Application by National Grid Electricity Transmission for the Sea Link Project

**East Suffolk Council's Post-Hearing Submission in relation to
Issue Specific Hearing 2 dealing with environmental matters, 28-30 January 2026**

Deadline 4 (10 February 2026)

Application: EN020026

**Viewpoint 1: Public Footpath (Saxmundham 460, route 23), east of Saxmundham, looking southeast**

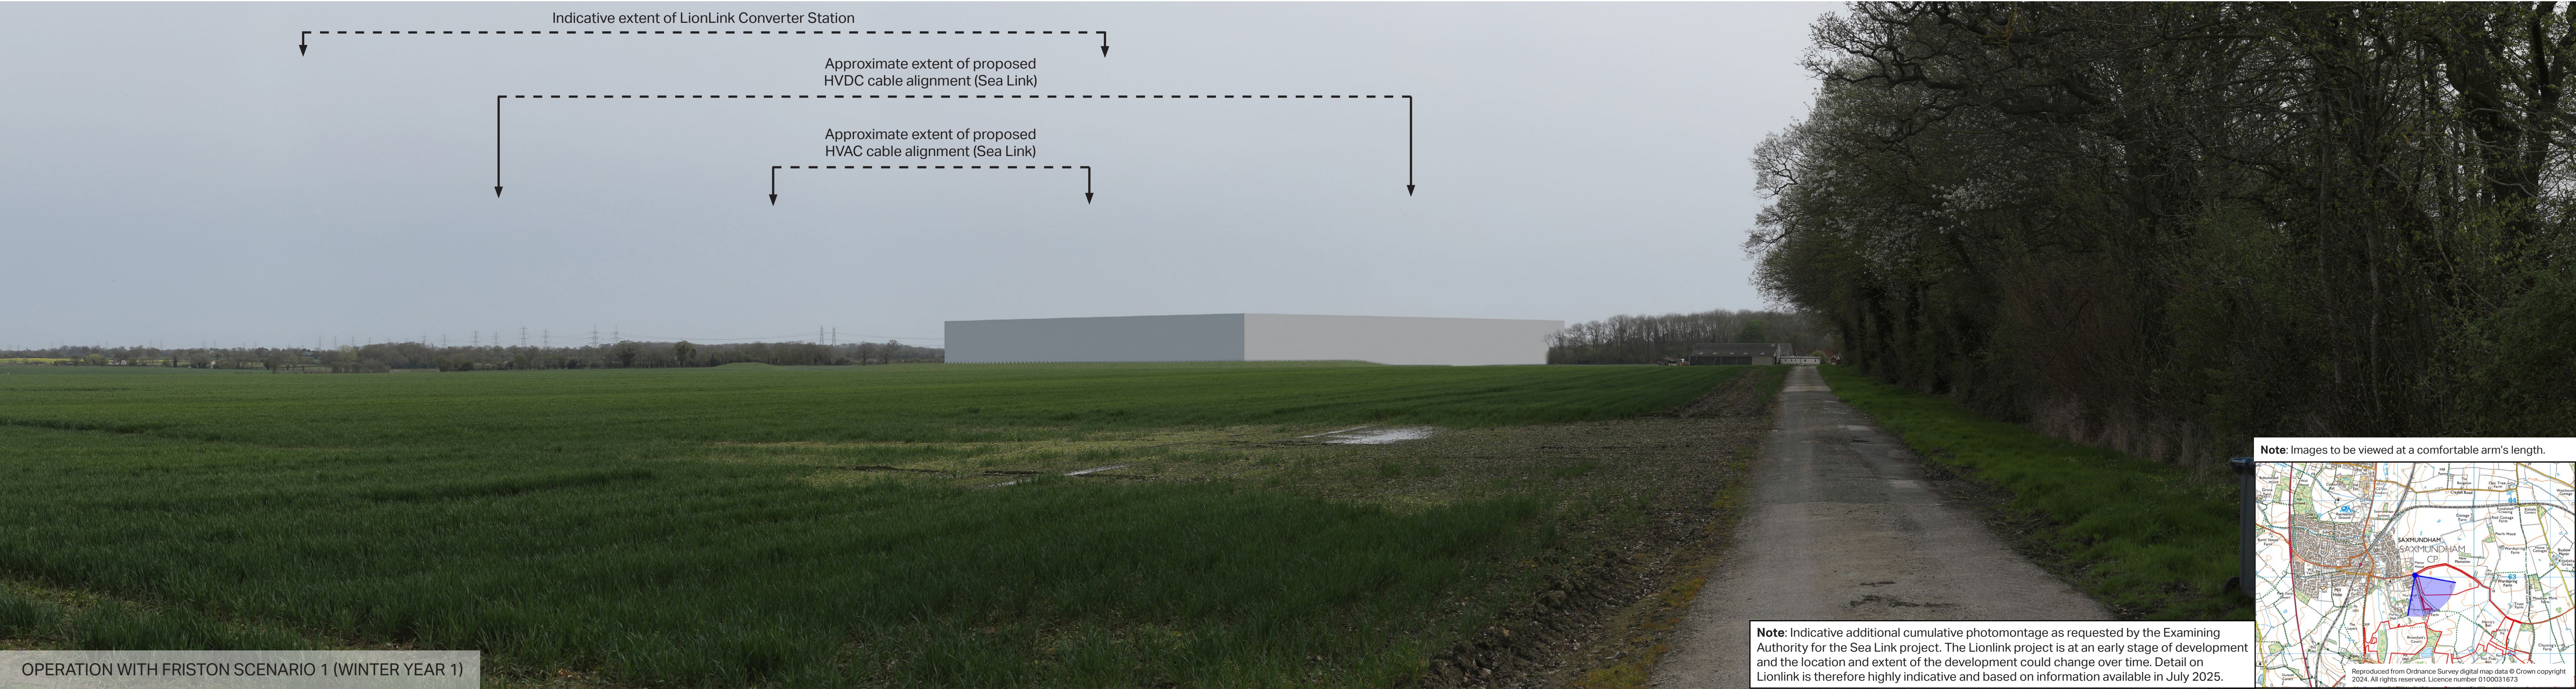
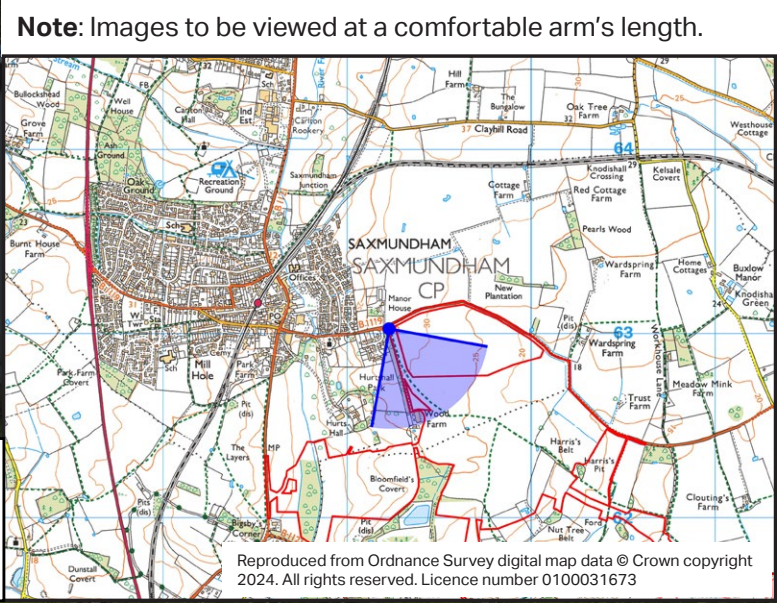
The Applicant also stated at ISH2 that such planting would channel views along the PRow towards the converter station site. ESC explained that it does not accept this suggestion and considers that Viewpoint 1 [\[APP-208\]](#) indicates such planting would screen, rather than channel, views towards the converter station site.
